Application WA/73/17/OUT

Response to comments from West Sussex County Council (highways) and Highways England

Written by : Gary Heard (Peter Brett Associates LLP)

28th November 2017

LARGE REFUSE VE
ANALYSIS - THROU

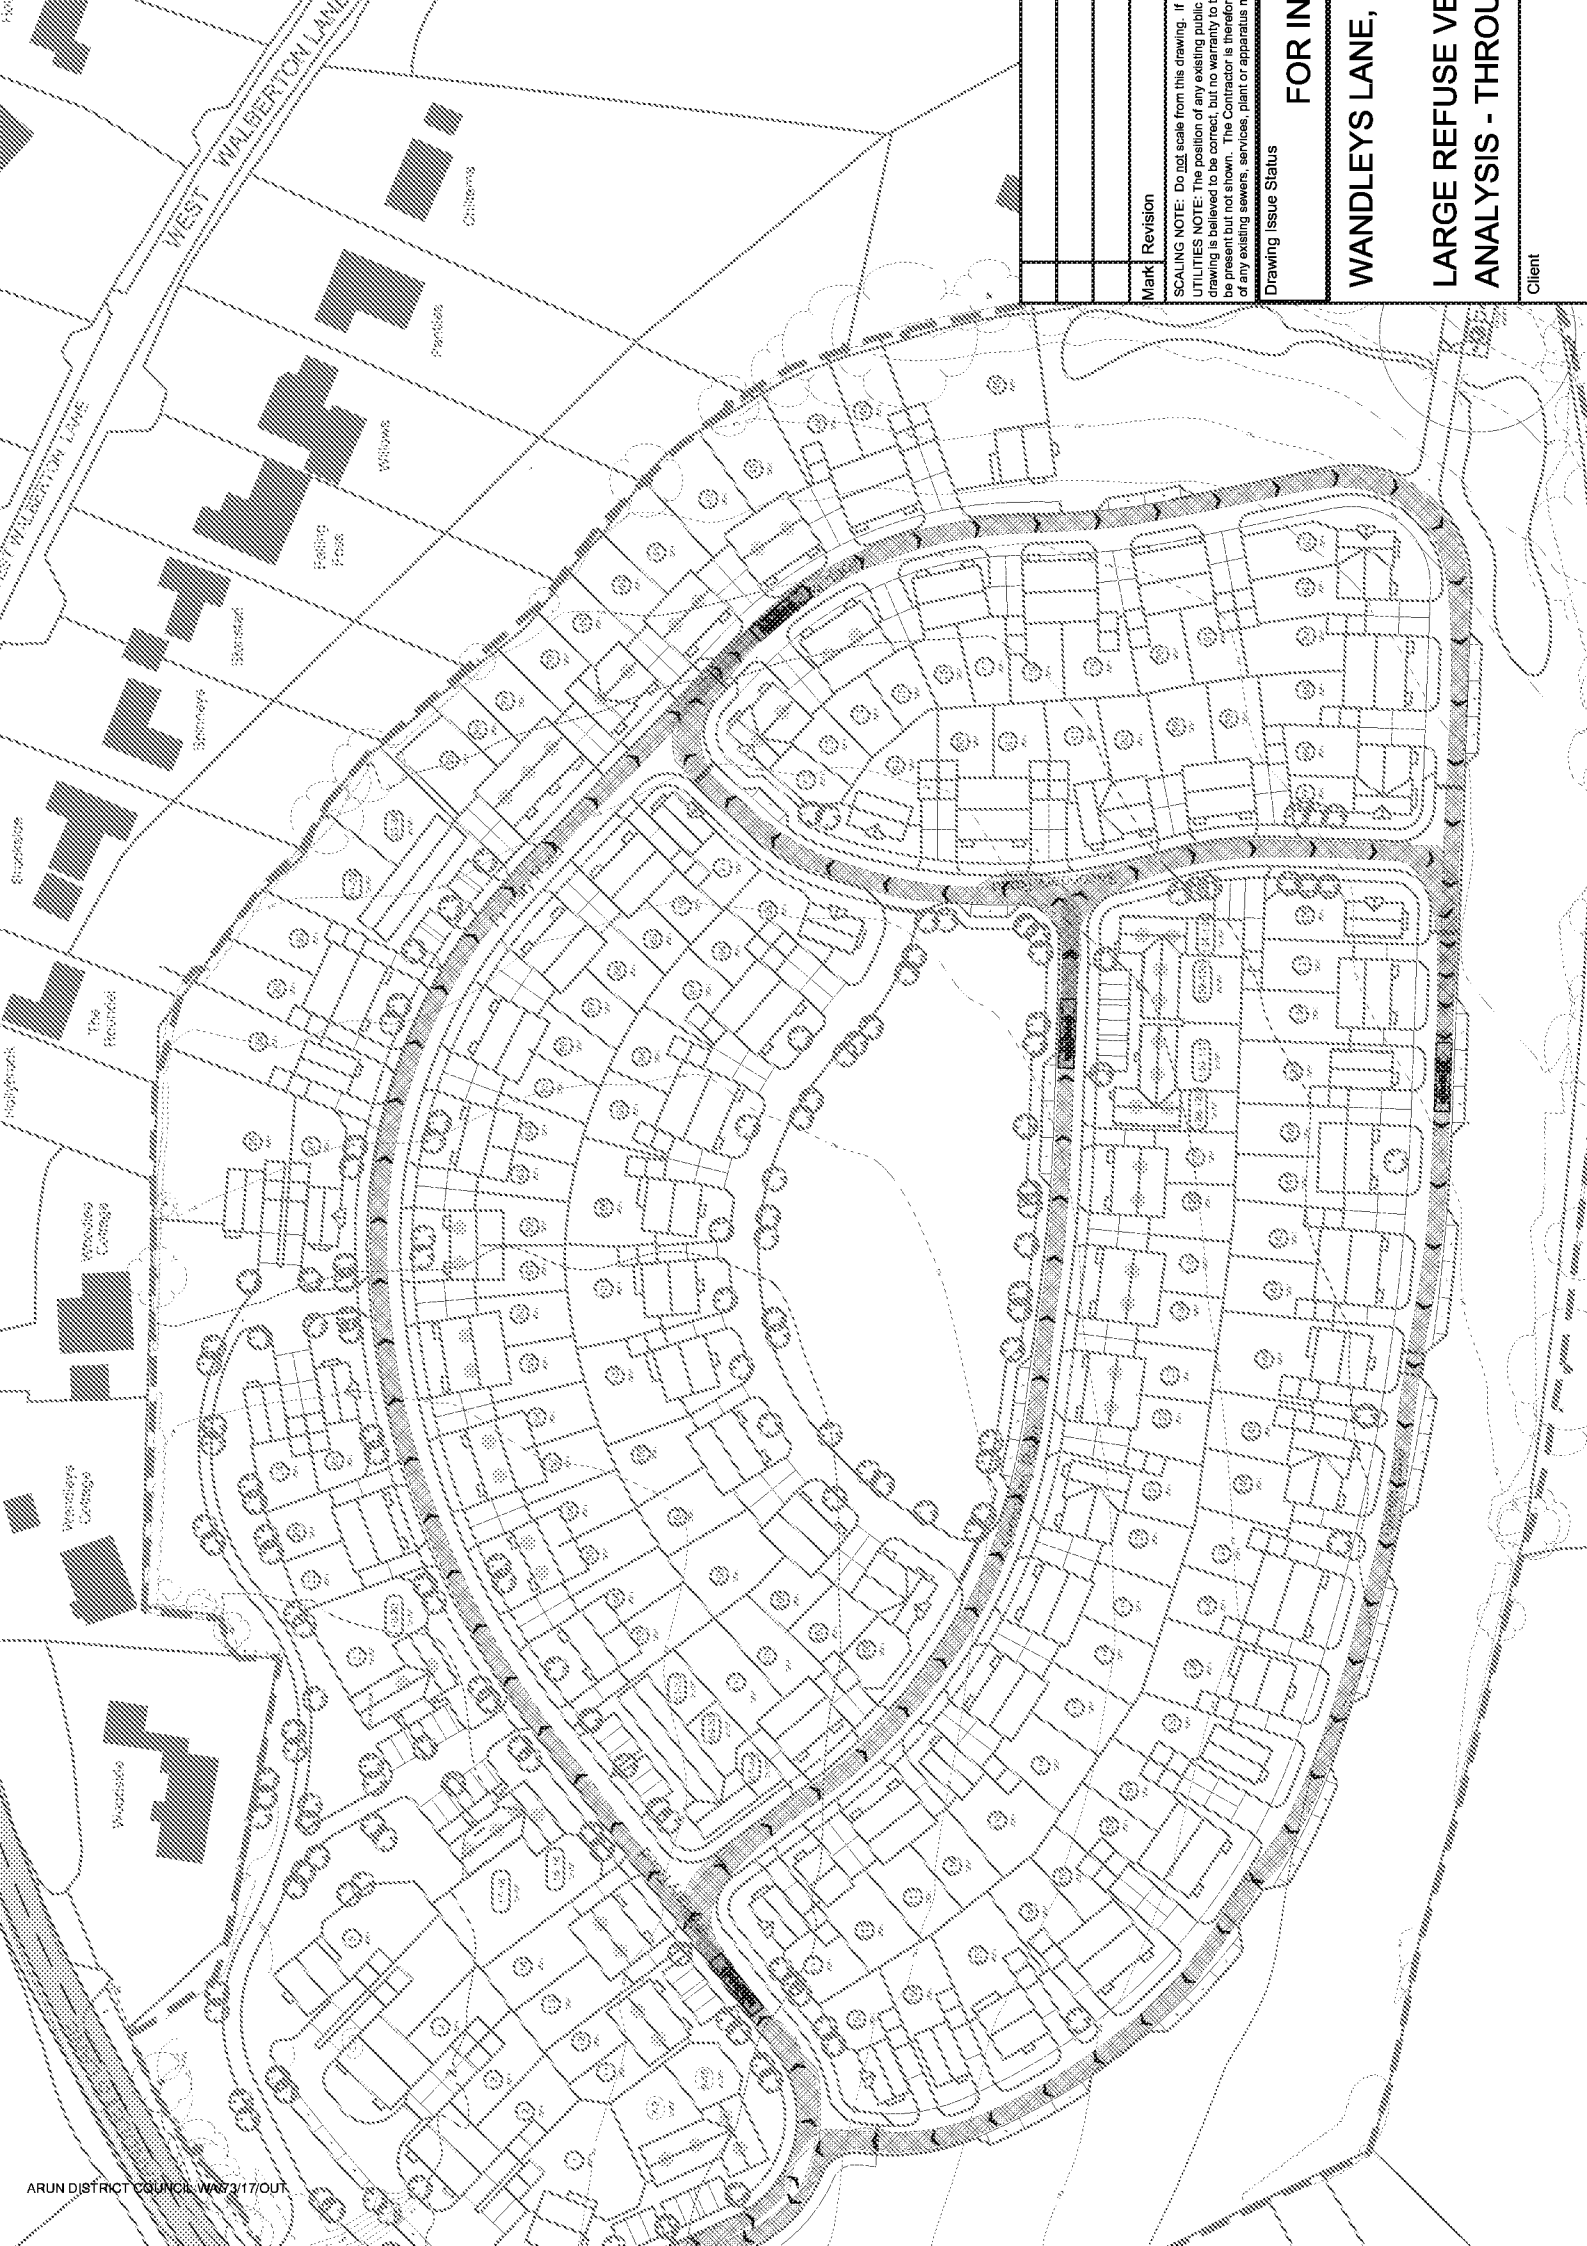
Vehicle tracking has been provided which appears to show a HGV can serve the site. A colour plan should be provided to confirm this.

Noted. A colour plan is now attached for reference.

Project:	ITB11324 Walberton
Title:	A27 / A29 signals (Fontwell Eastern Rbt)
Location:	
File name:	2031 Sensitivity A27_A29 Fontwell E Rbt.lsg3x
Author:	AL
Company:	i-T
Address:	
Notes:	To Systra dwg 103800_D007

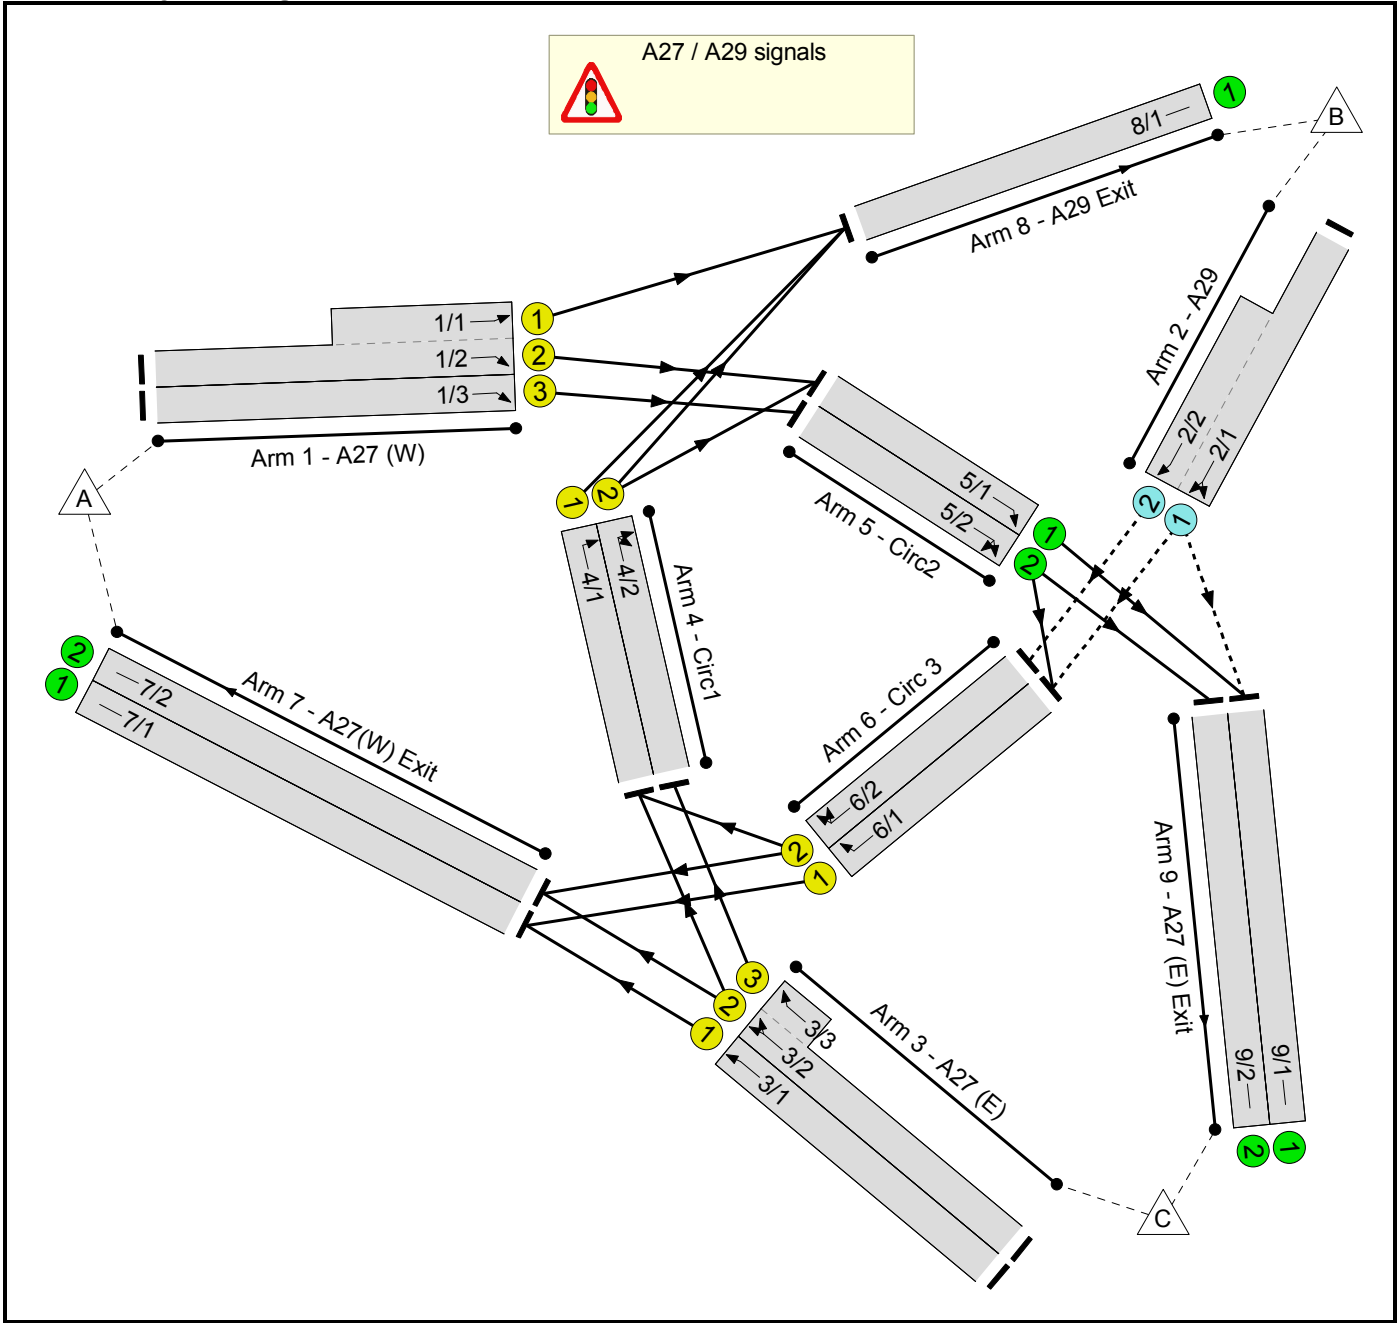
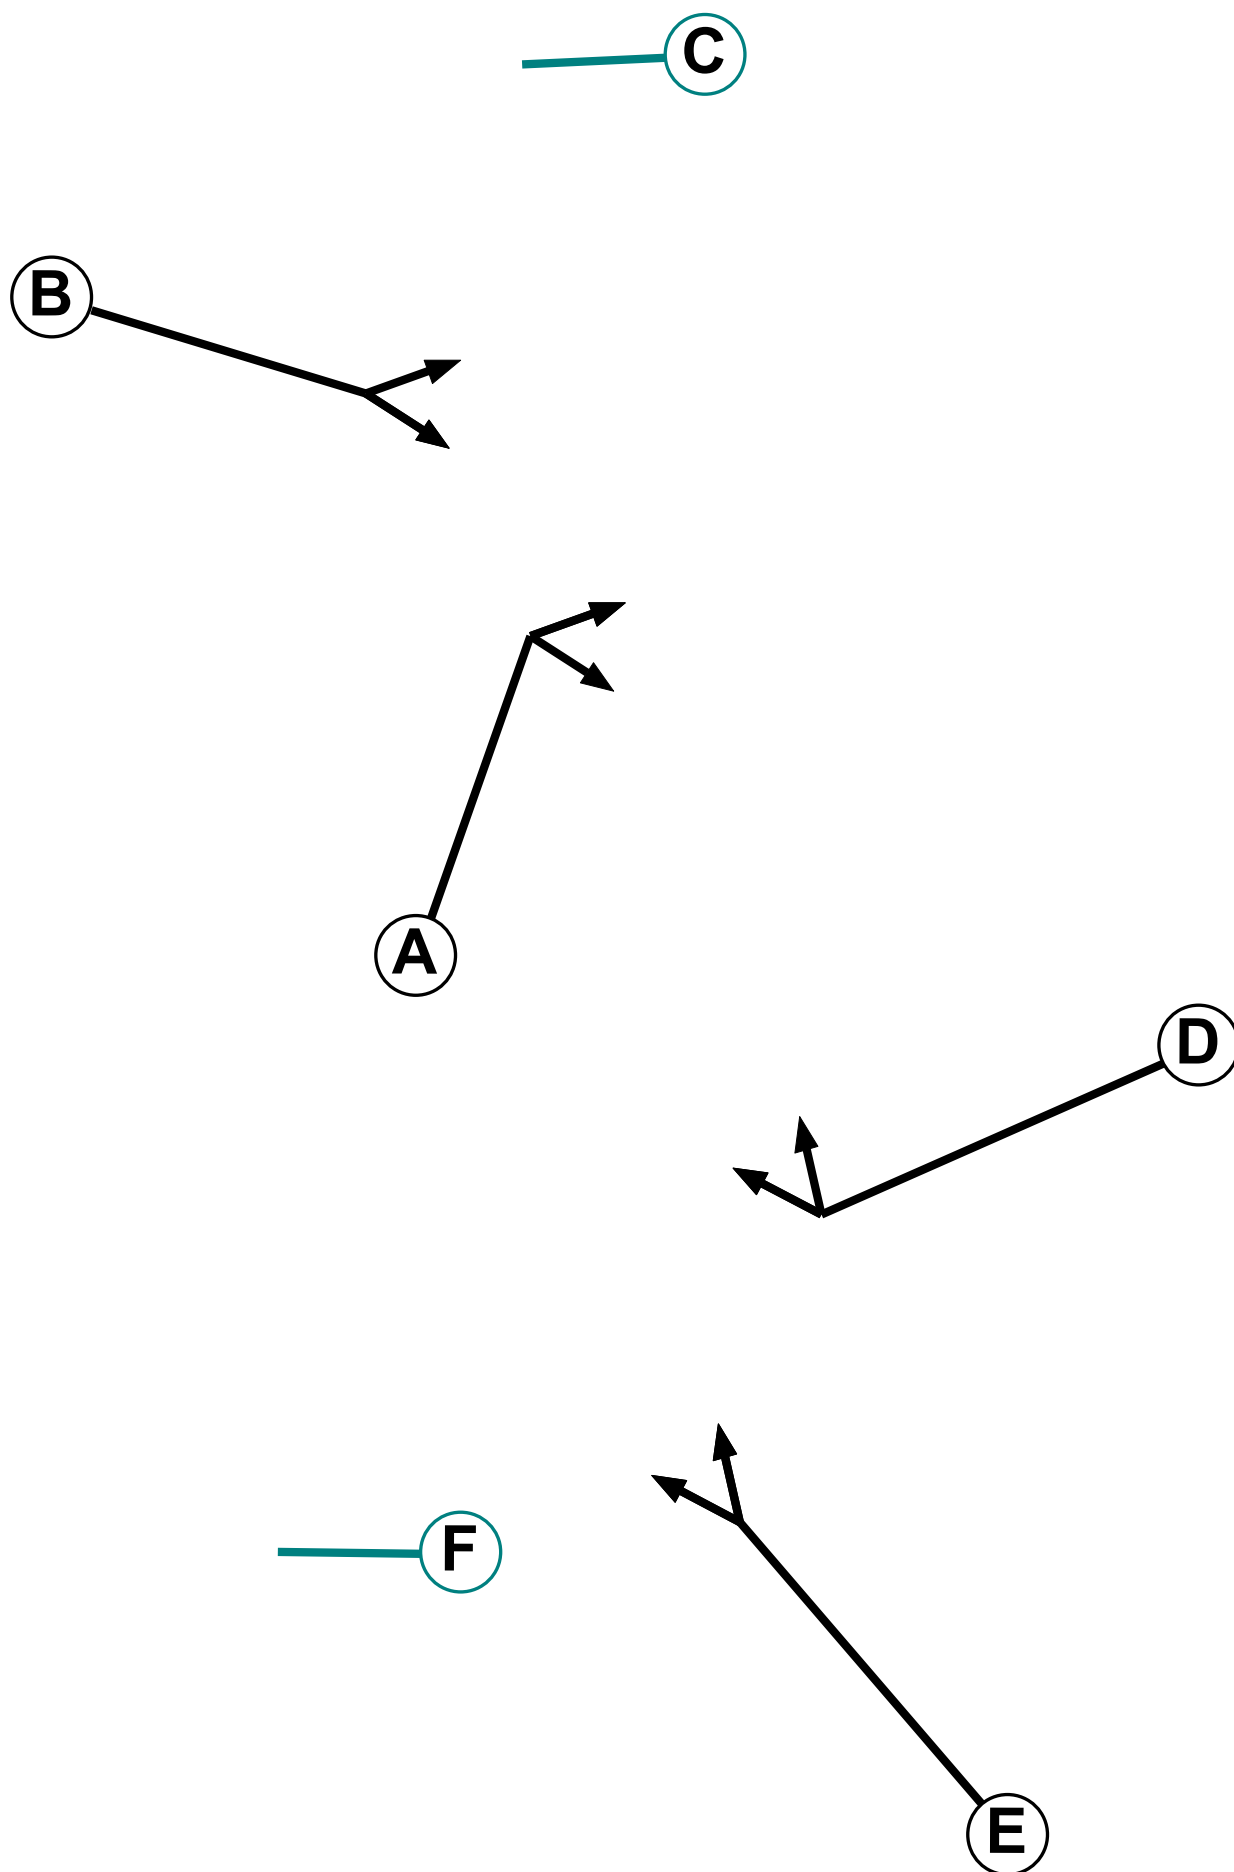
- Our initial analysis of the geometry suggests: Lane 2/2 's physical lane length in the model is too long. There is 127 metres to the next junction and the model has a lane length of 60 PCU. Lane 3/1's physical length seems to be too long, as it appears to be around 3 PCUs. Lane 4/1's physical lane length is too long, as it appears to be around 10 PCUs.

- All circulatory lanes are modelled as having a physical lane length of 60 PCUs, and thus this should be amended as it is incorrect, while a lane width of 5m for the circulatory appears generous.

- Clarification is sought as to whether saturation flows are geometrically calculated or directly inputted?

- The comment relating to the geometry of certain links is a comment that WSCC would need to respond to (or direct to their consultants) as these are inputs to the model supplied to PBA by WSCC.

- The model we have been provided with by WSCC (and have adopted for assessment) assumes that saturation flows are geometrically calculated.
- The modelling files area attached.
